EPC STORMWATER REVIEW COMMENTS  
 IN ORANGE BOXES WITH BLACK TEXT

## EL PASO COUNTY STORMWATER MANAGEMENT PLAN CHECKLIST

EPC Project Number: **SF2318 & PPR2320**

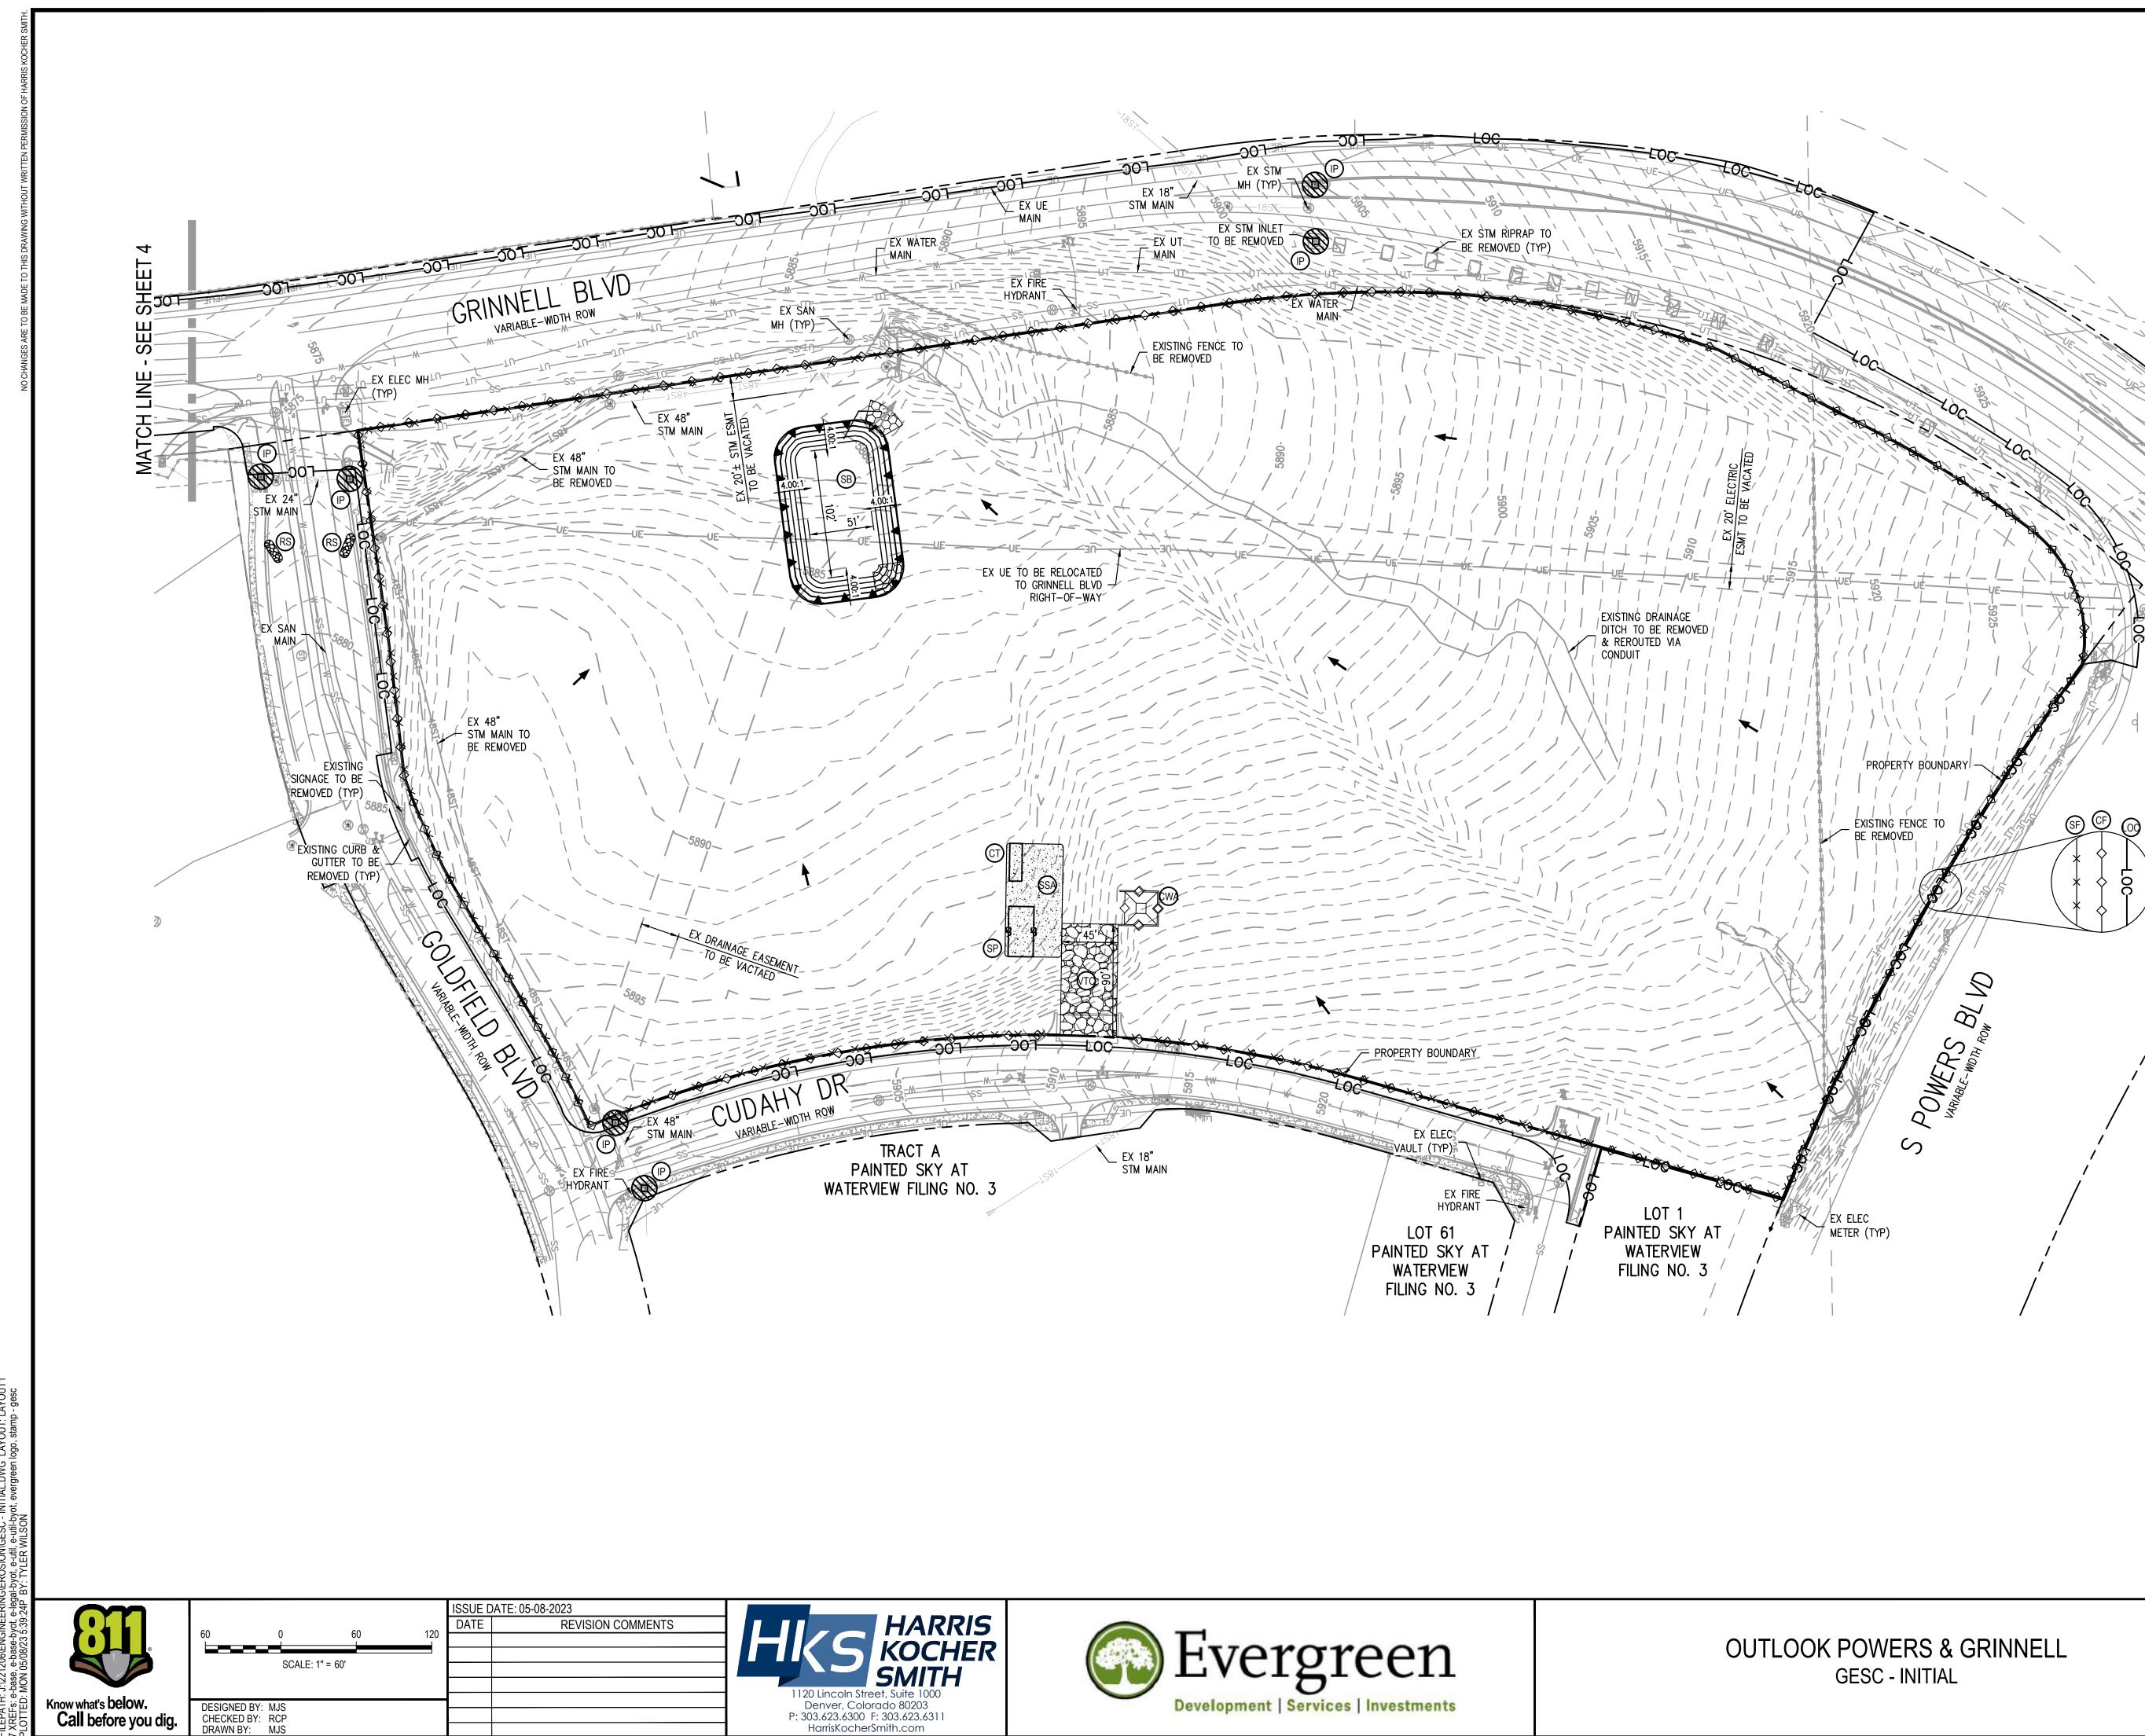
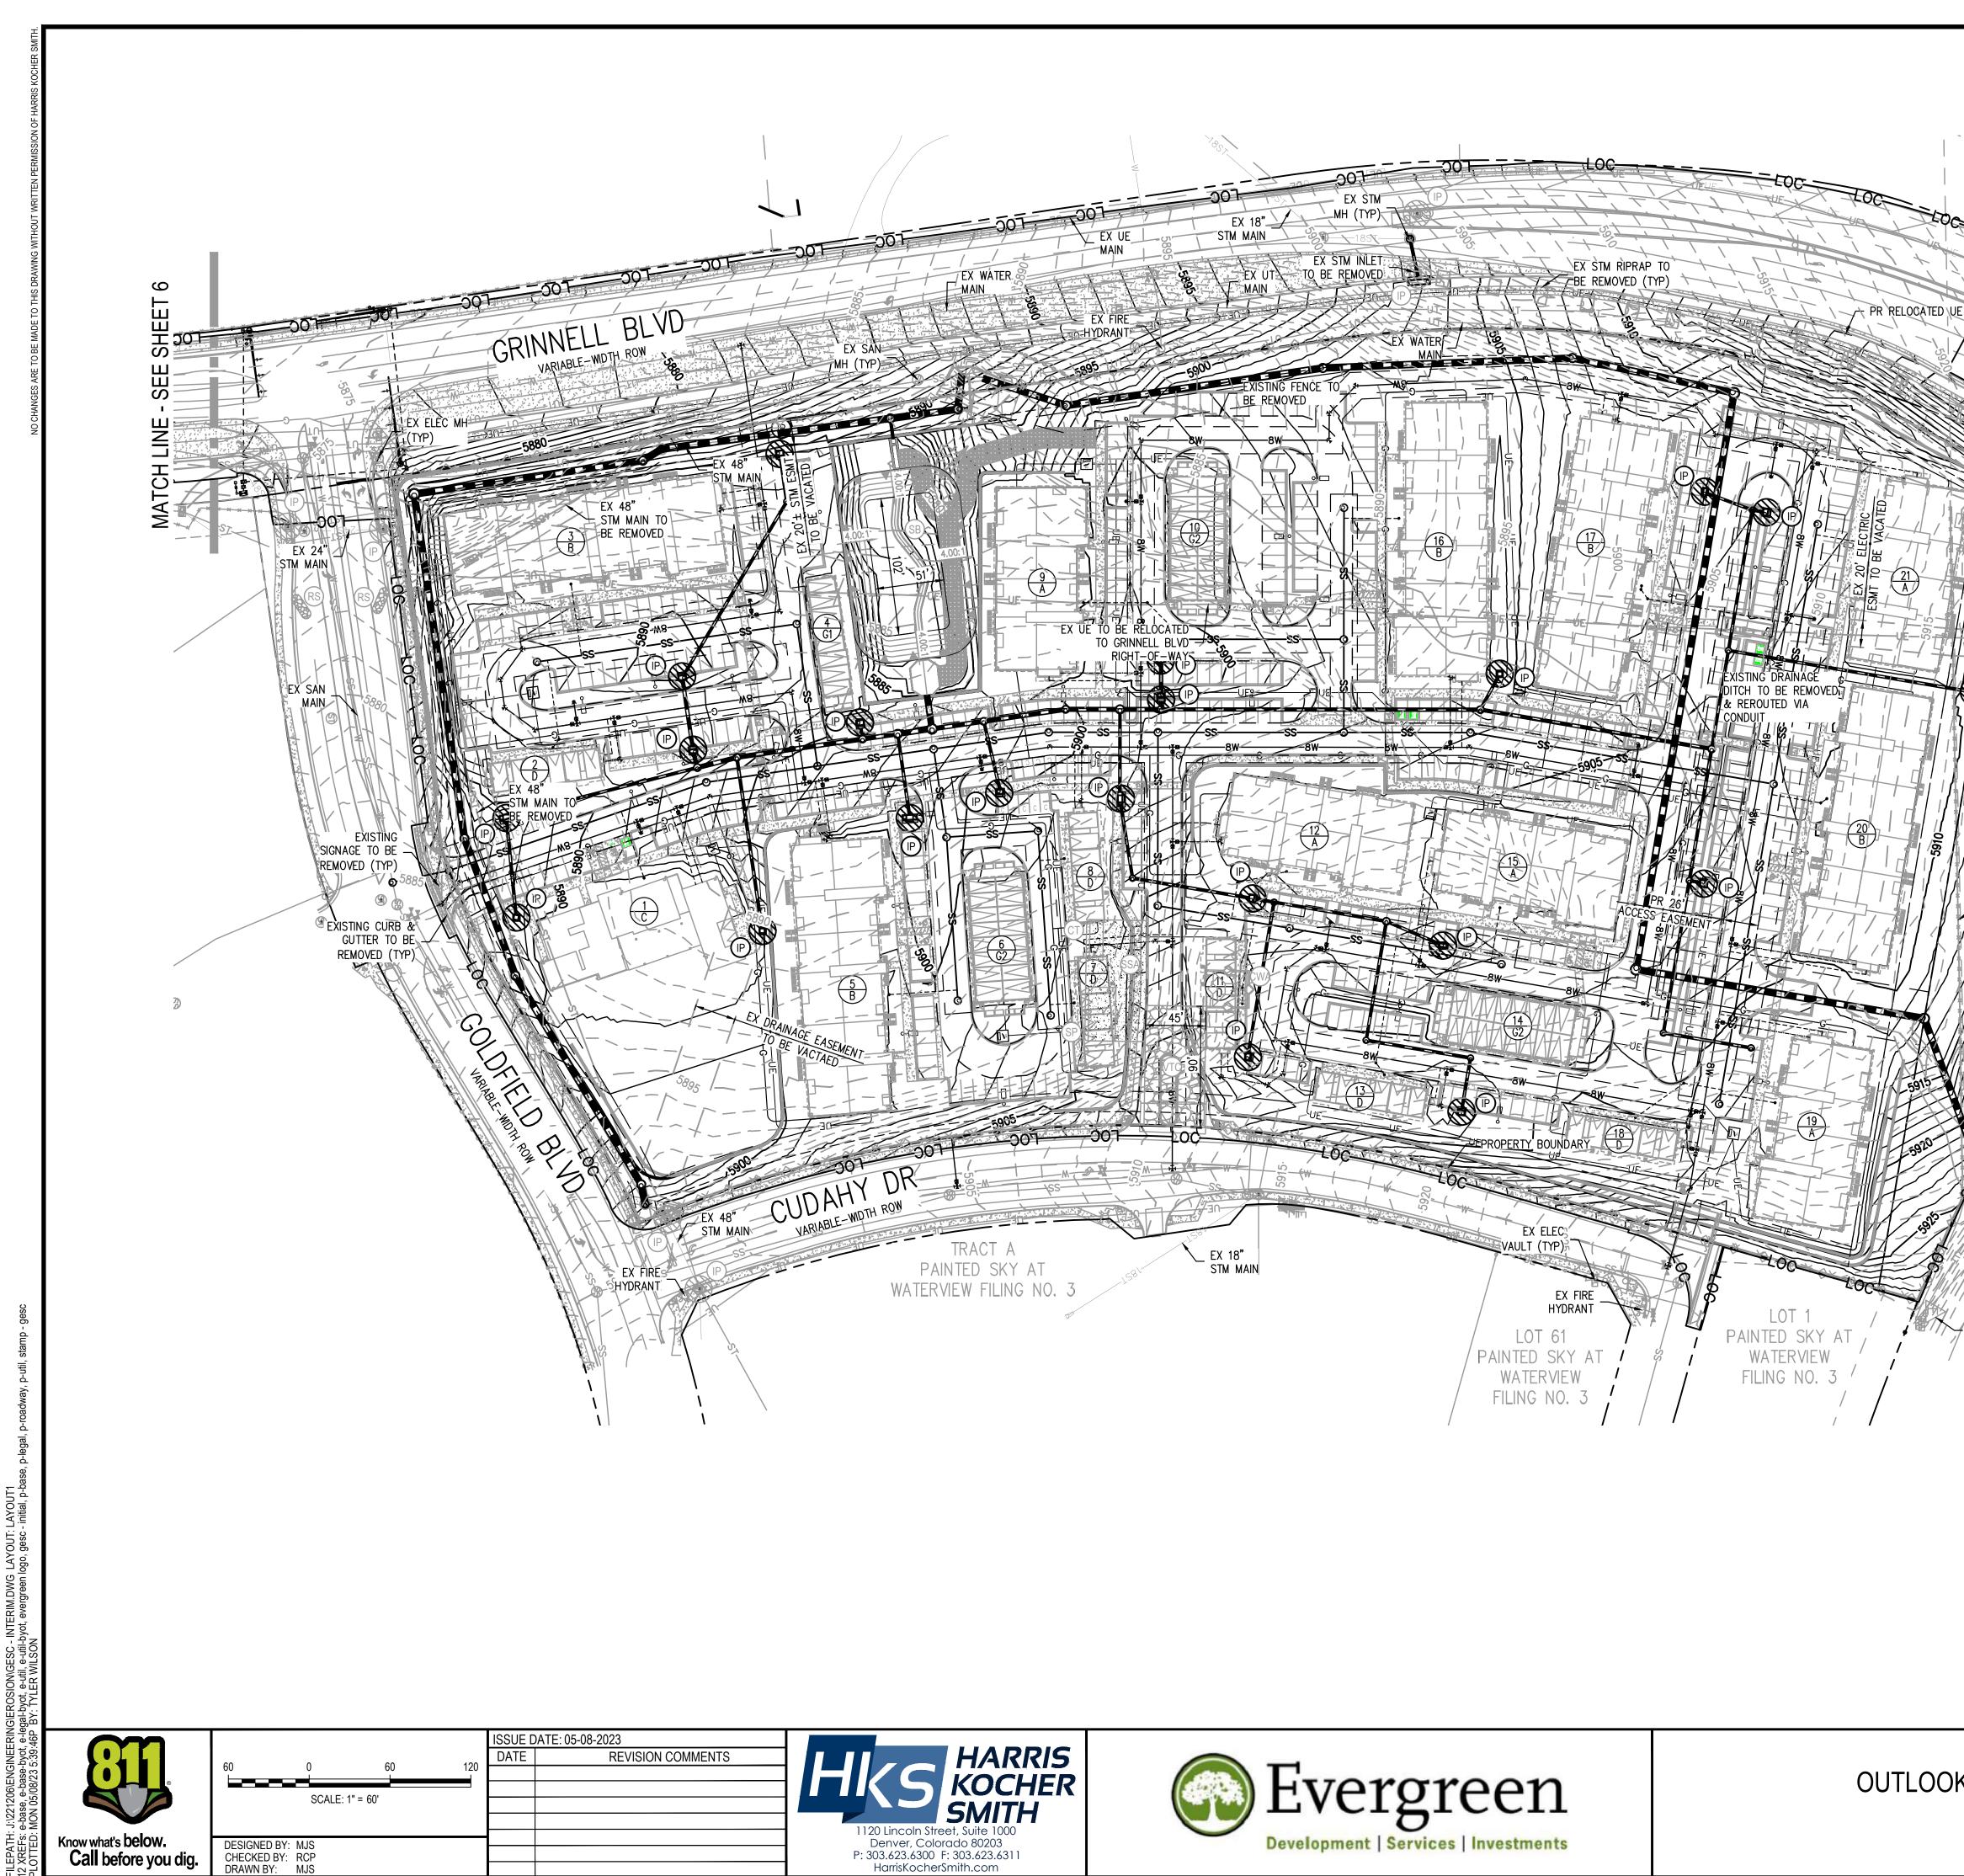
Applicant	EPC
17	SWMP Map to include: <b>Reviewed the GEC Plan</b>		
17a	construction site boundaries		Y
17b	flow arrows to depict stormwater flow directions		Y
17c	<b>all areas of disturbance</b>		N
17d	<b>areas of cut and fill</b>		N
17e	areas used for storage of building materials, soils (stockpiles) or wastes		Y
17f	<b>location of any dedicated asphalt / concrete batch plants</b>		N
17g	location of all structural control measures		Y
17h	<b>location of all non-structural control measures</b>		N
17i	springs, streams, wetlands and other surface waters, including areas that require maintenance of pre-existing vegetation within 50 feet of a receiving water		Y
18	Narrative description of all structural control measures to be used. Modifications to EPC standard control measures must meet or exceed County-approved details		Y
19	Description of all non-structural control measures to be used including seeding, mulching, protection of existing vegetation, site watering, sod placement, etc.		Y
